# CITY OF PORTLAND BUILDING PERMIT

Job ID: 2011-11-2785-FAFS

has permission to install plaza master box fire alarm system

## **Conditions of Approval:**

Little Caesar's

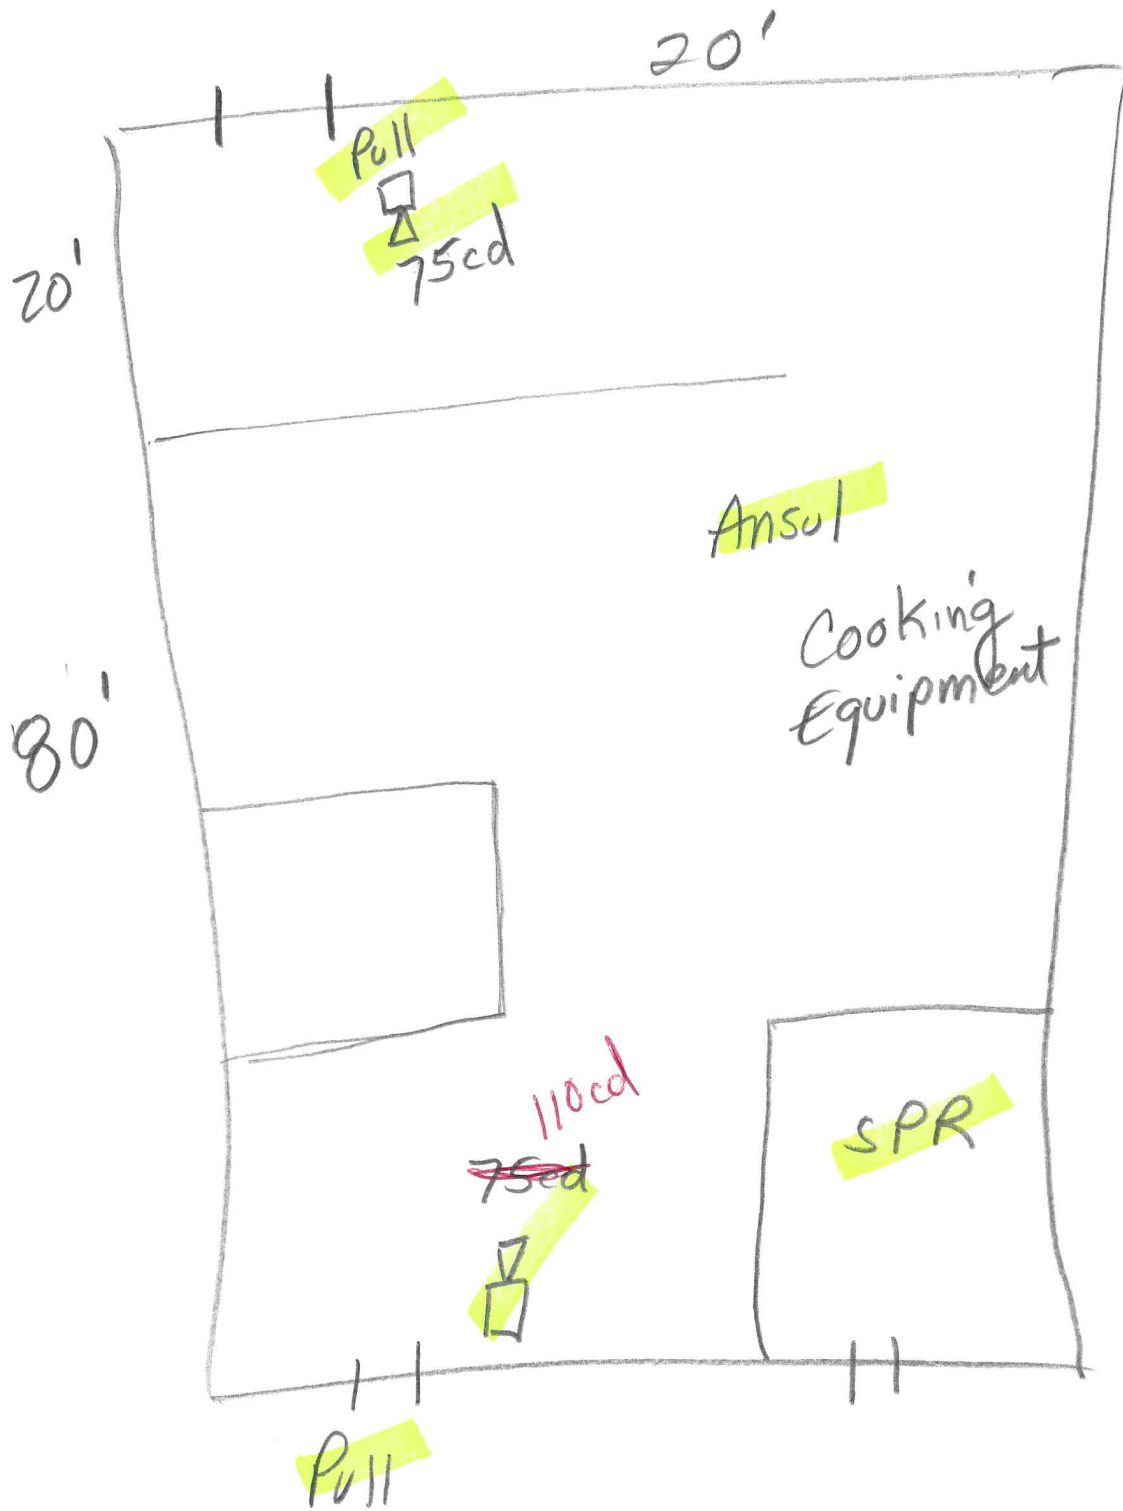
The Dollar Tree bathroom hallway and Little Caesar's kitchen space needs proper visual notification appliances.
